WEST SUSSEX COUNTY COUNCIL CONSULTATION

TO:	Arun District Council FAO: Amber Willard	
FROM:	Highways, WSCC	
DATE:	12/12/2018	
LOCATION:	Florabunda, Bilsham Road, Yapton, BN18 0JN	
SUBJECT:	Y/78/18/HH Vehicular access.	
DATE OF SITE VISIT:	N/A	
RECOMMENDATION:	☒ Advice ☐ Objection ☐ Modification ☐ No Objection ☐ More Information ☐ Refusal	
S106 CONTRIBUTION TOTAL:	£N/A

Flora Bunda, Bilsham Road, Yapton, Arundel

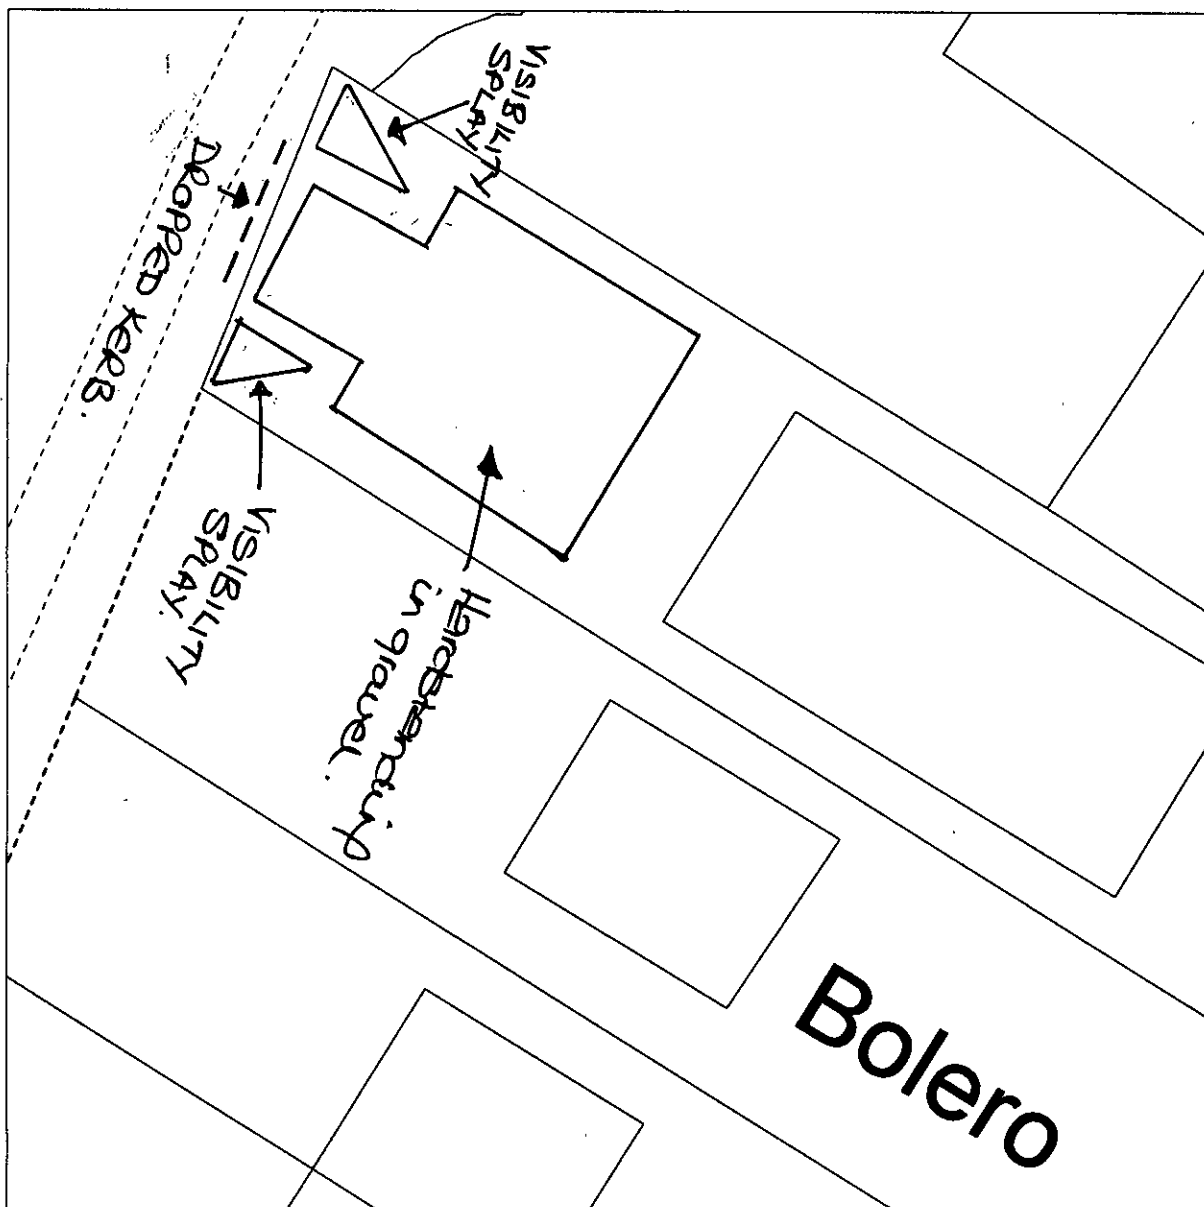
The proposed plans indicate that the proposed VCO will be approximately 4m in width. A licence will be required for the proposed access and must be constructed to a specification agreed with the Local Highway Engineer.

The proposed plans demonstrate pedestrian visibility splays, however these do not appear to have been drawn to WSCC standards. Due to the proximity of the site to bus stops and local shops and services, there is a benefit to ensuring that pedestrian visibility is maintained. Pedestrian visibility splays should be taken 2m back into the access and a distance measured along the back of the footway for 2m on each side of the access, as demonstrated below. There should be no obstructions over 0.6m within these splays. Details of pedestrian visibility can be secured via condition.

The proposed plans indicate that parking for two vehicles will be provided on site. The proposed area of hardstanding meets the minimum specifications of 2.4 x 4.8m per parking space as set out in Manual for Streets. A turn on site would be preferred however neighbouring properties operate similar arrangements without evidence of safety concern.

No part of the development shall be first occupied until pedestrian visibility splays of 2 metres by 2 metres have been provided either side of the proposed site vehicular access onto Bilsham Road in accordance with plans and details to be submitted to and approved in writing by the Local Planning Authority. These visibility splays shall thereafter be kept free of all obstructions over a height of 0.6 metre above adjoining carriageway level or as otherwise agreed.
